Peter Fisher
Head of Third Party Infrastructure
Strategic Projects Division
National Highways
The Cube
199 Wharfside Street
Birmingham
B1 1RN

10 January 2022

THE LONDON RESORT – RESPONSE TO EXAMINING AUTHORITY PRE-EXAMINATION QUESTIONS – DECEMBER 2021

This letter provides a response from National Highways (formerly Highways England) to the Examining Authority's (ExA) questions in their letter dated 21 December 2021, addressed to London Resort Company Holdings (the Applicant), all interested parties, and affected persons, relating to the forthcoming examination of The London Resort Development Consent Order (DCO).

Ref. 6.3.3.2

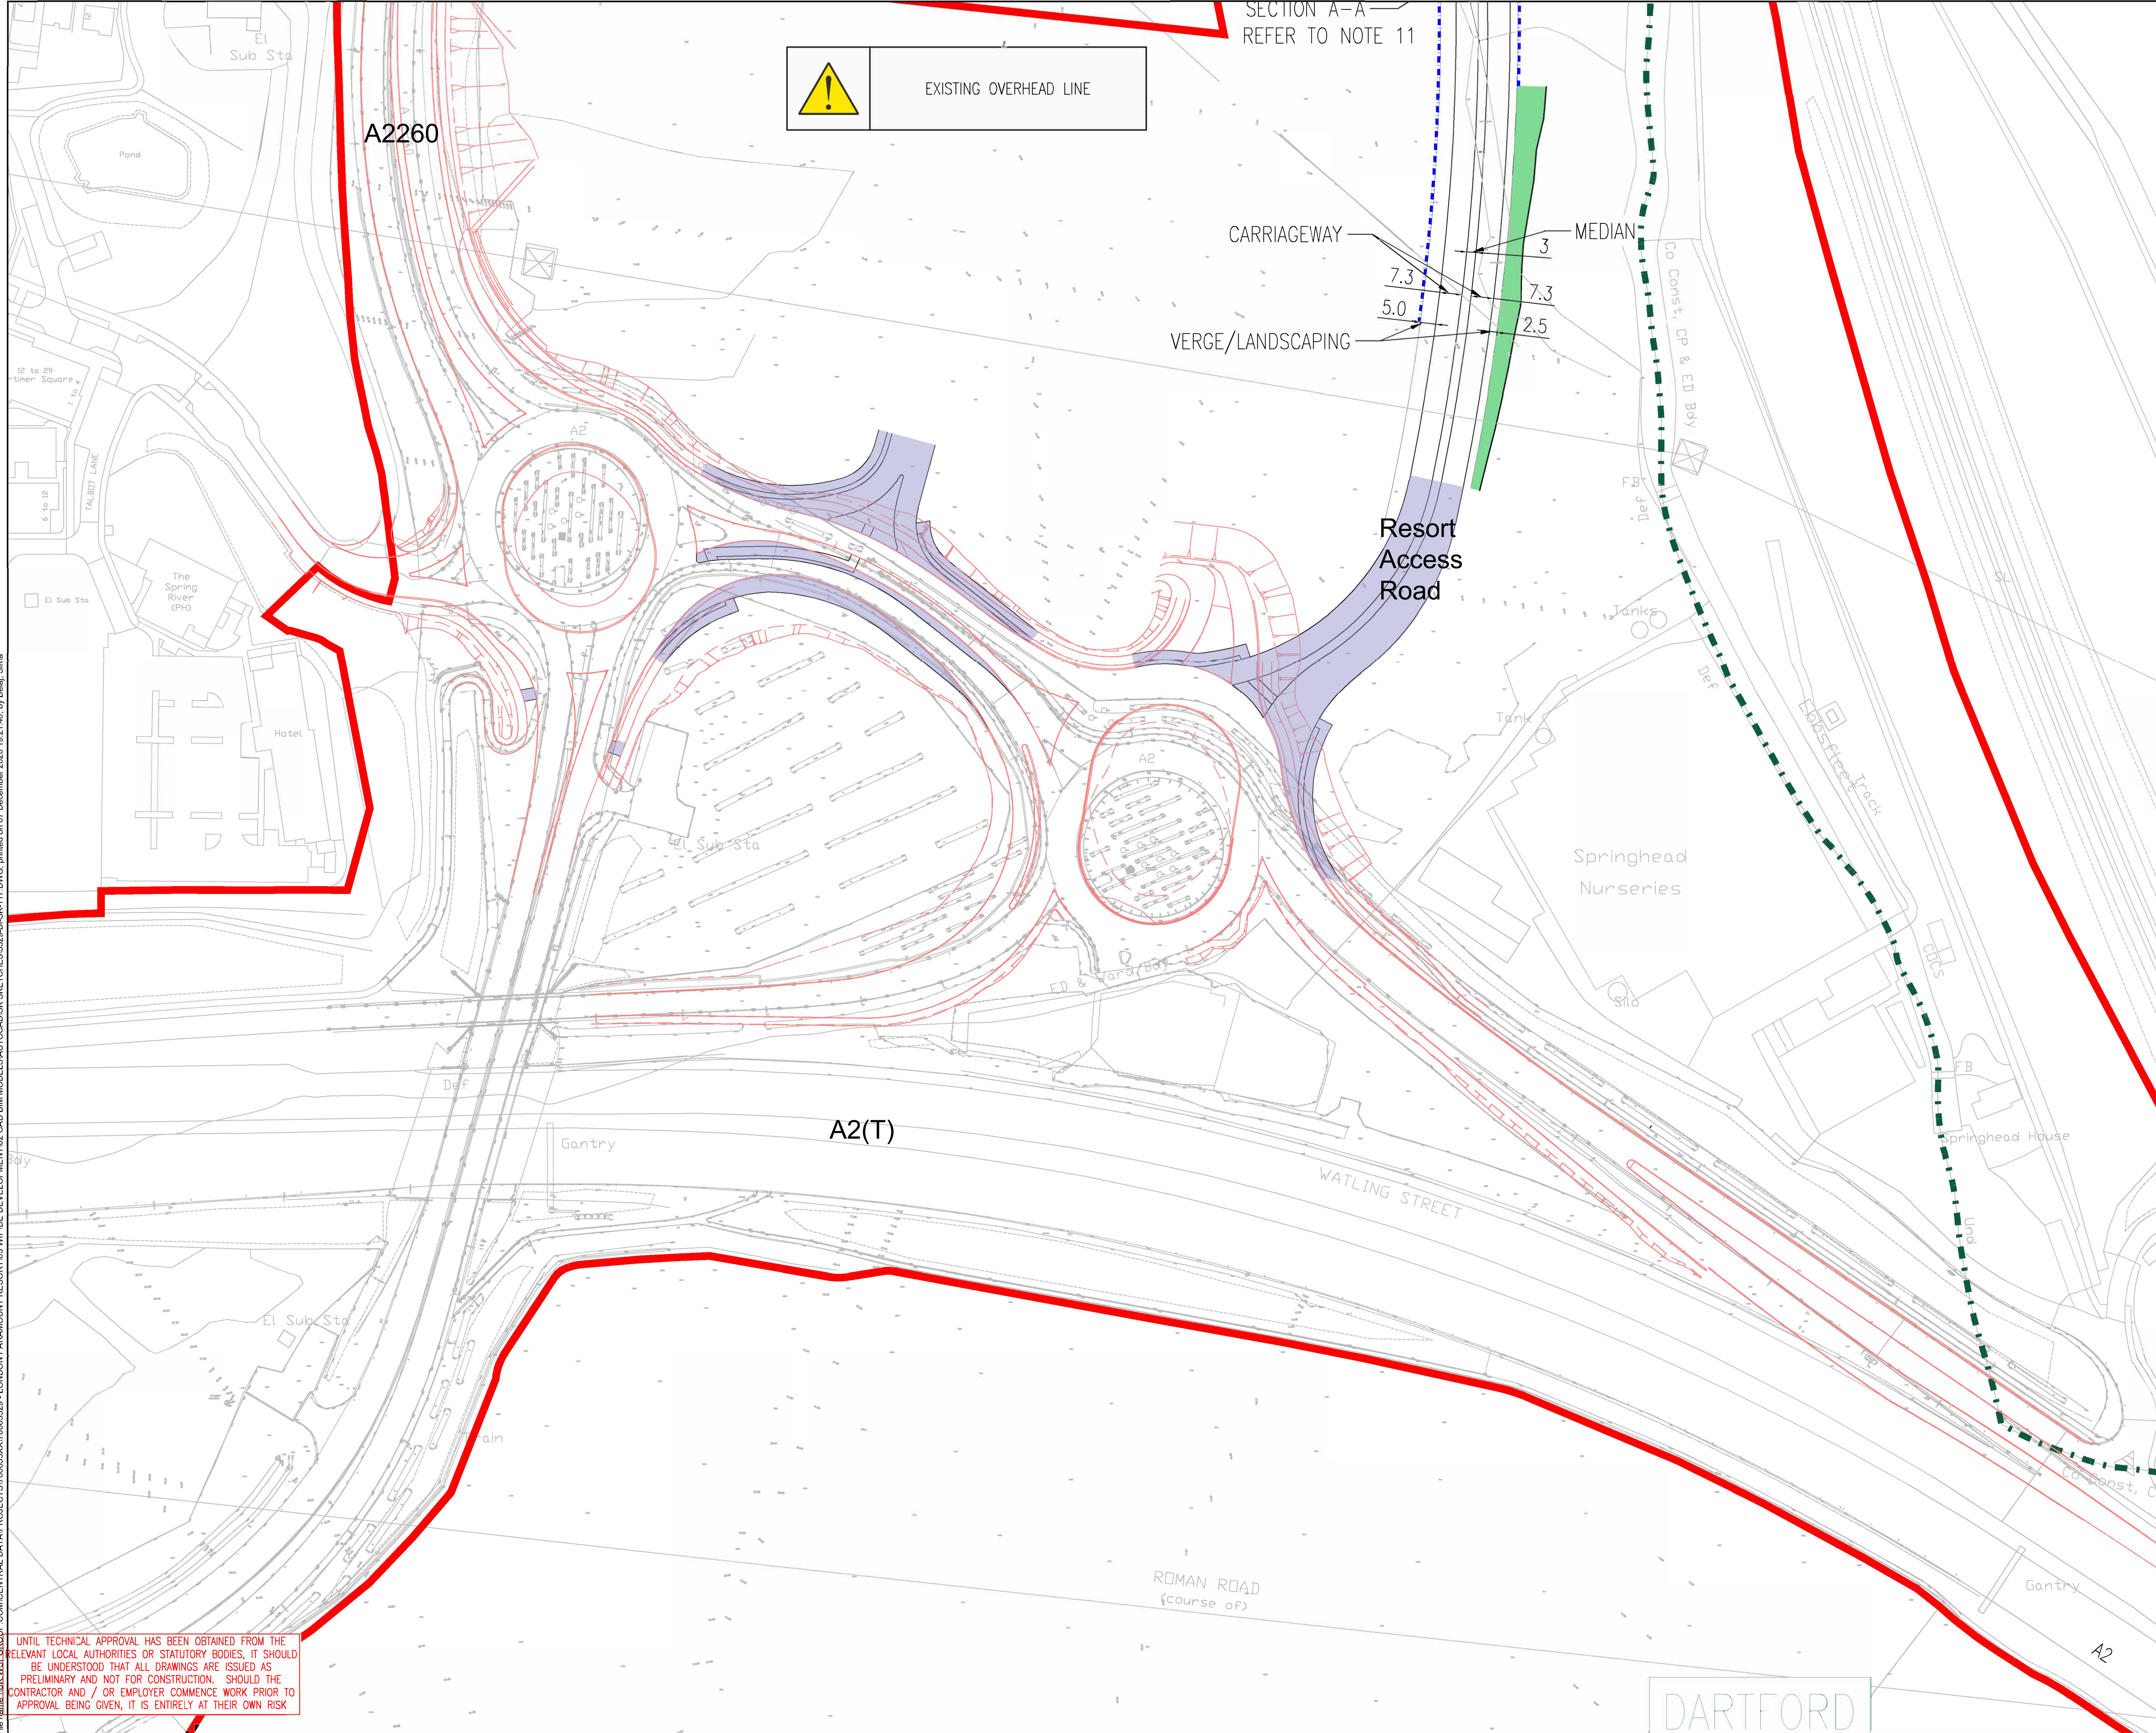
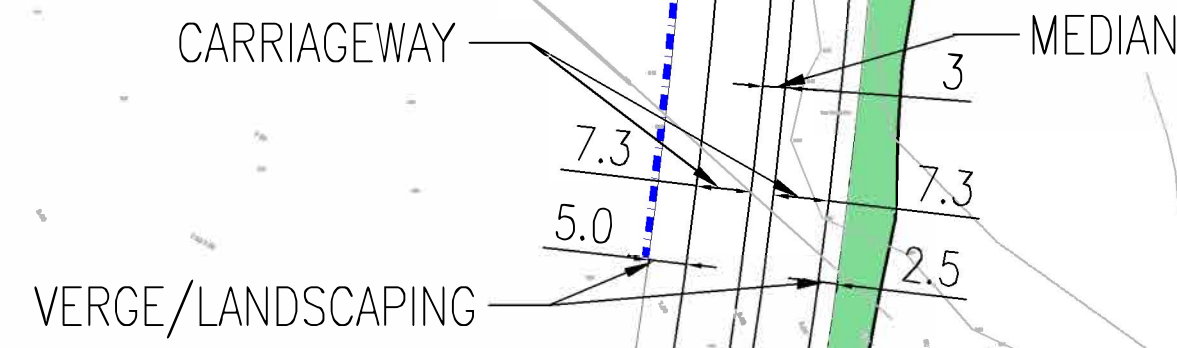
The DCO application proposes SRN mitigation schemes at the A2 Bean & Ebbsfleet junction and the A1089 Asda Roundabout. However, as stated above, until matters in relation to the transport assessment are resolved, we cannot agree the proposed mitigation or assess whether additional mitigation is required. If further mitigation schemes were required outside the DCO Order limits this could have significant implications for the application. In relation to the proposed SRN mitigation schemes, it should also be noted that the Applicant has not yet provided supporting information, such as the interim Road Safety Audit (RSA) and Walking, Cycling and Horse-riding Assessment (WCHAR) which we would ordinarily expect to have reviewed by this stage.

The Applicant advised National Highways in November 2021 that they are seeking to alter their land acquisition proposals in relation to the A2 Bean & Ebbsfleet junction. We have asked for further clarification on this matter but are yet to receive this.
